Application No: BR/13/22/HH
Site Address: 235 Hawthorn Road Bognor Regis PO21 2UW
Description of works: Erection of two storey side extension and single storey rear orangery following the demolition of existing rear conservatory and side extension.

Thank you for your internet representation made on 4th February 2022 which has been recorded as an objection with the comments as follows:

REAR ELEVATION PROPOSED 1:100

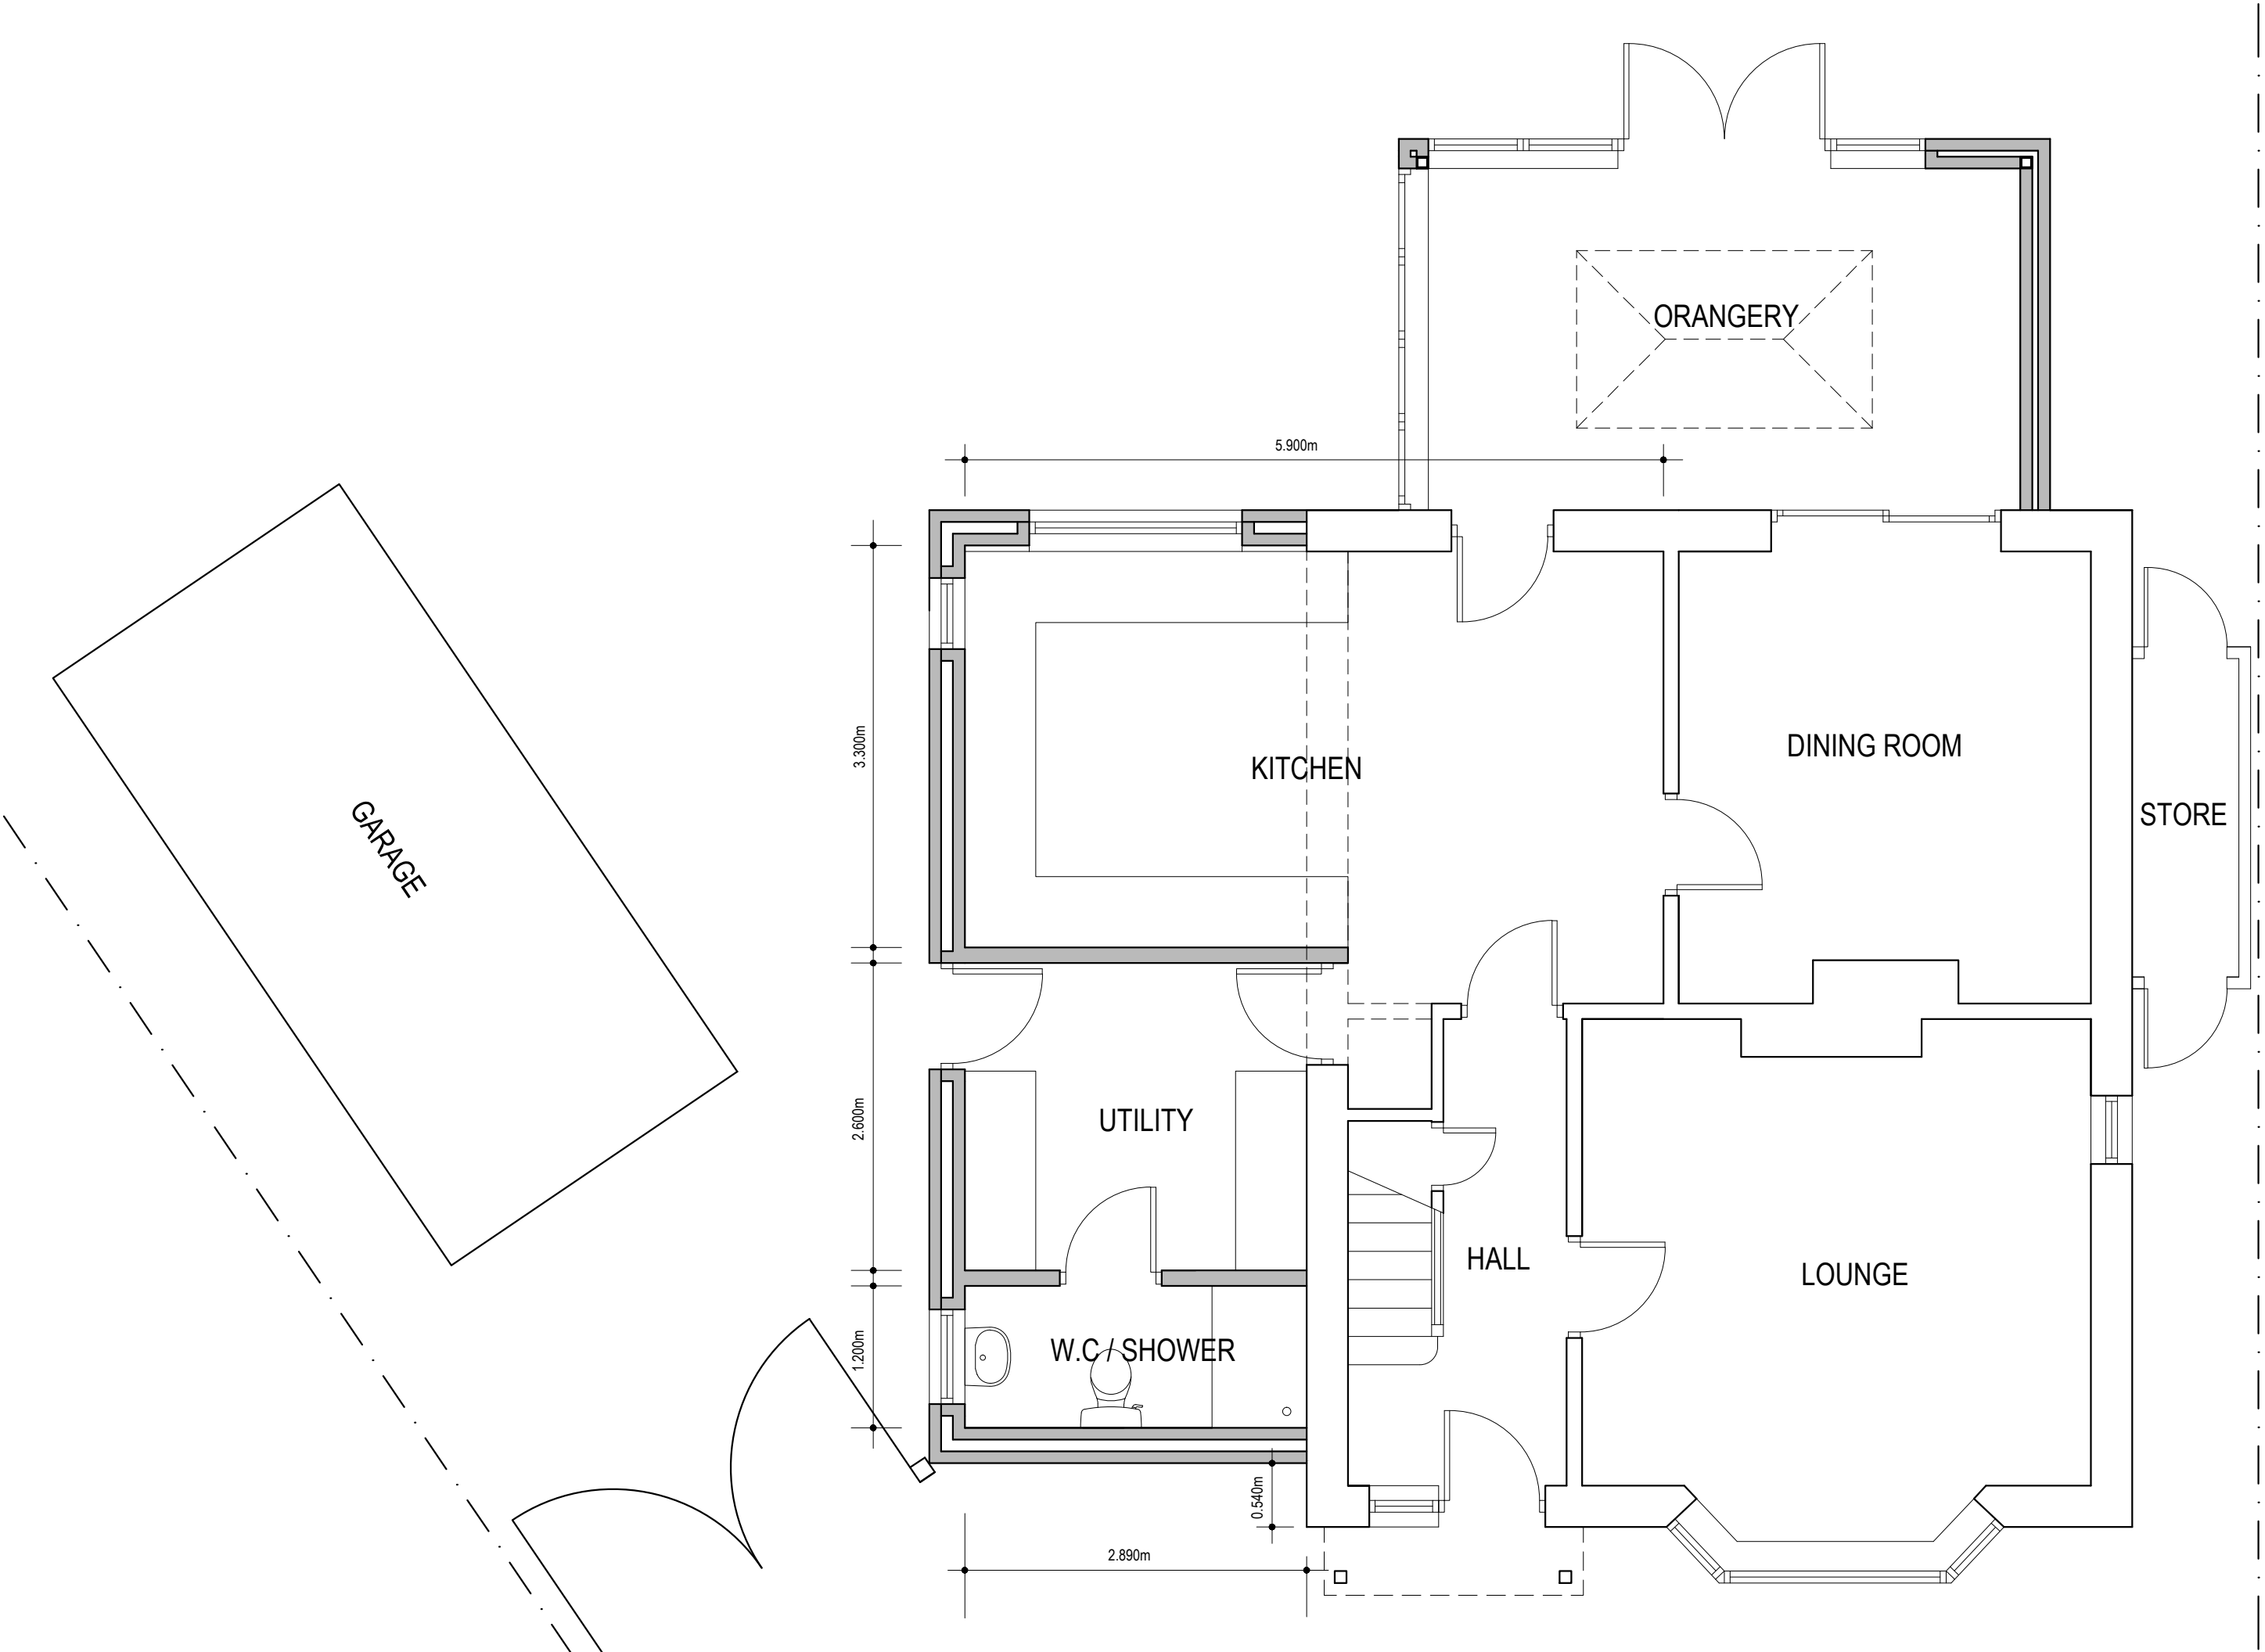
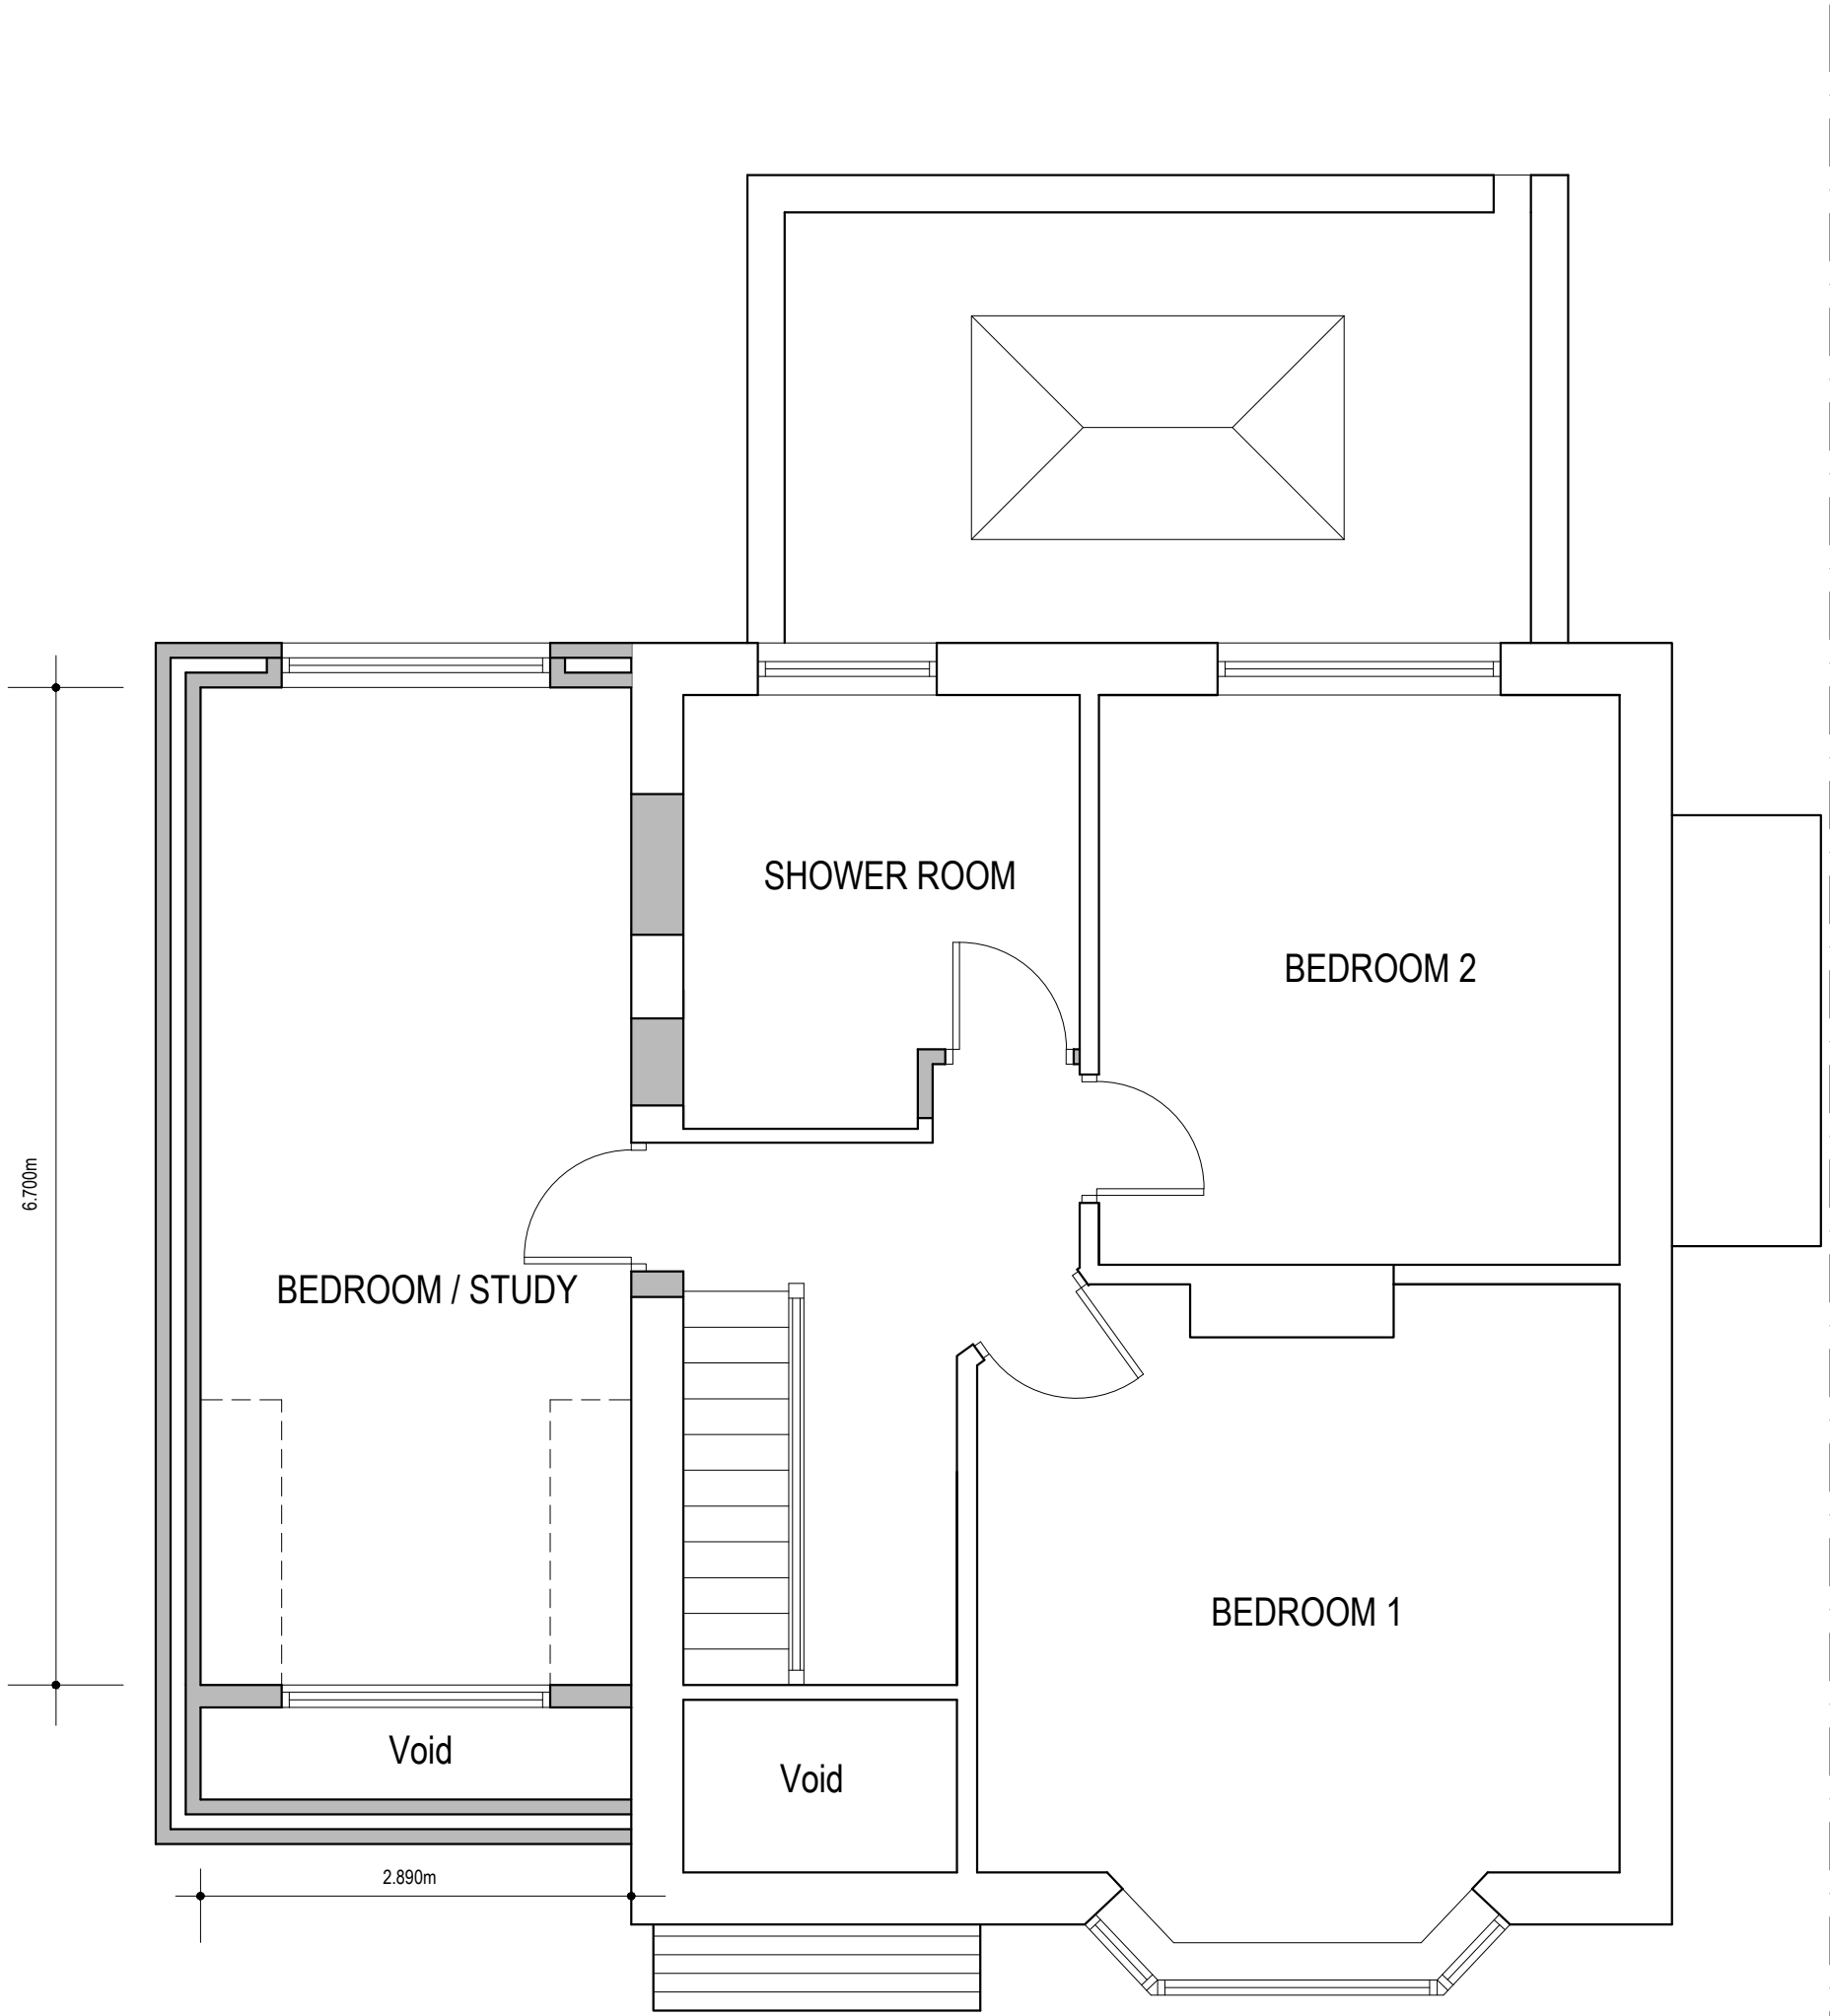
Due to the proposed house being situated on a fairly acute bend on Hawthorn road any windows on the rear of the property at a second story will permit a dual aspect view into multiple homes on crescenta walk.
Whereas we have no effected impact from the proposed development in principle we do take extreme objection to the windows on the second story resulting in zero privacy for the kitchen/ family room and garden of our property and many others on crescenta walk.

Concern is raised to further concrete structures affecting what appears to be a fairly high water table already? I hope consideration can be taken in to the application in omitting the windows to the rear elevation on the second story.
